Reference 21/01713/FULL

Subject Lower Maypole Cottage Maypole Lane Goudhurst Cranbrook

Proposal: Erection of a log store and potting shed and replacement doors to existing garage. (part retrospective)

Heritage Consultation Response

drawing title
**proposed garage/logstore
 plan & elevations**

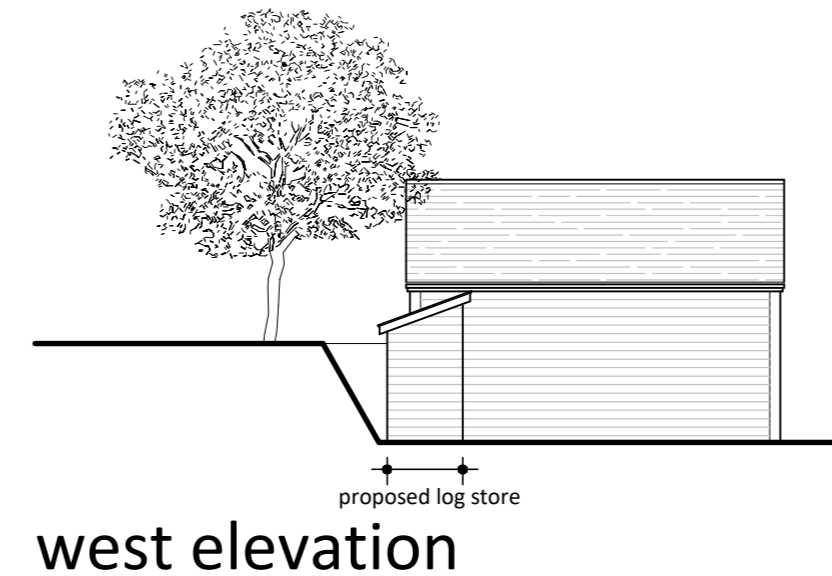
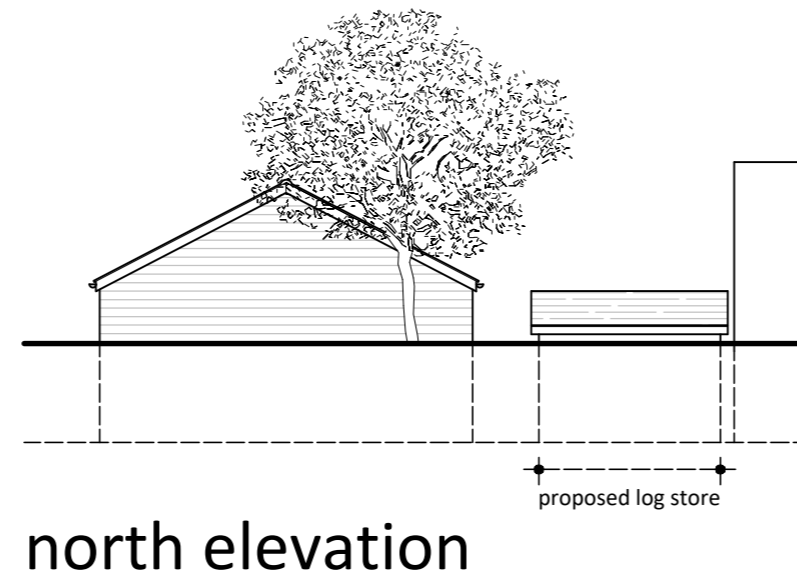
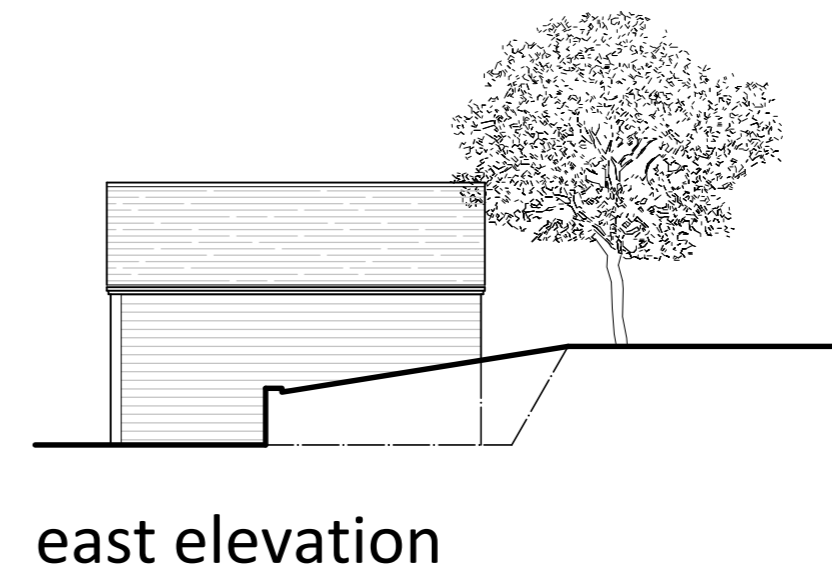
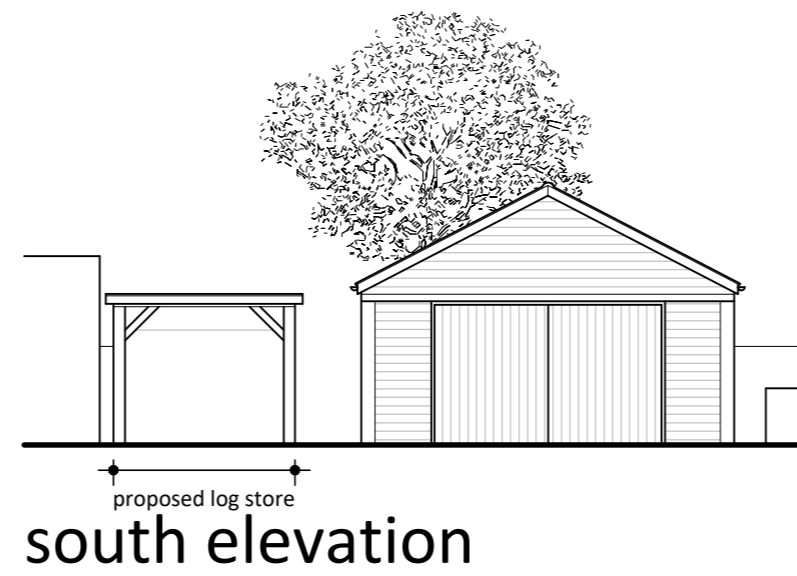
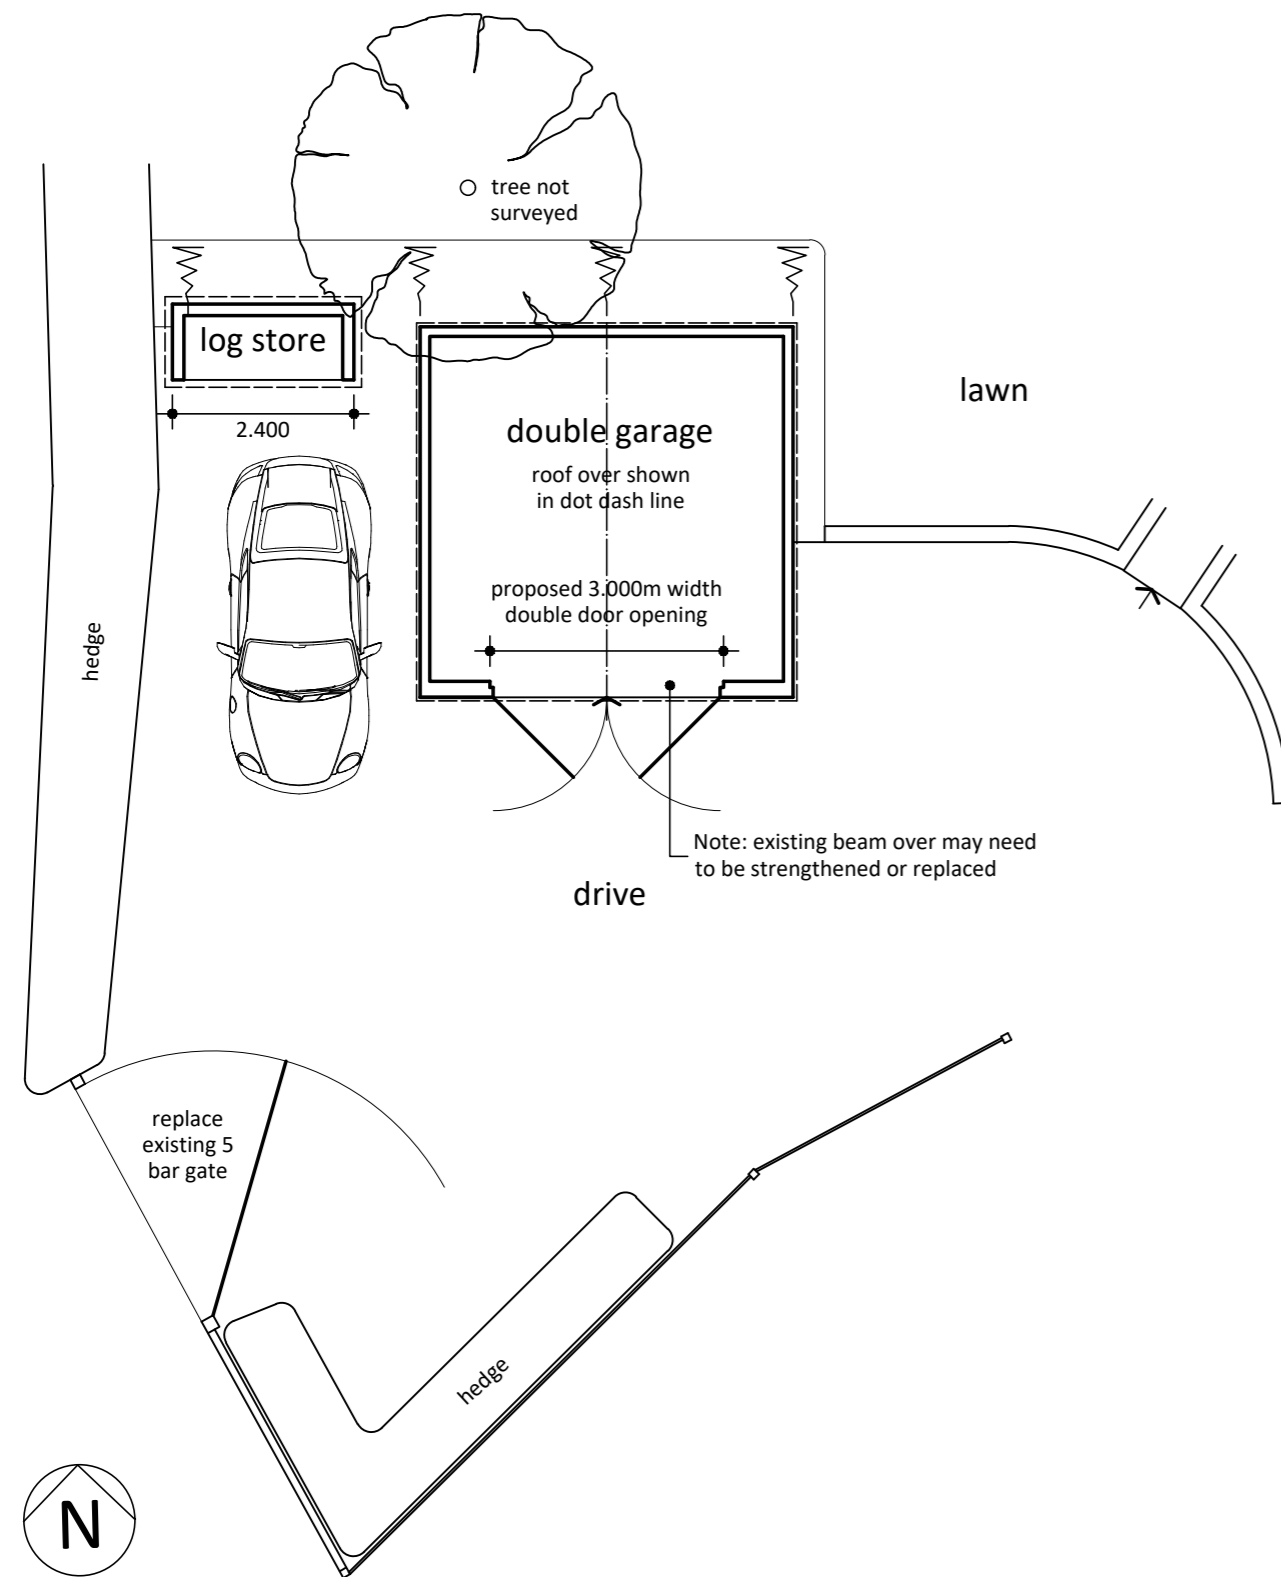
The proposal for reconfiguration of the existing garage doors will not have an impact of the setting of the listed building

The wood shed is of such a size as to have no impact on the setting of the listed building
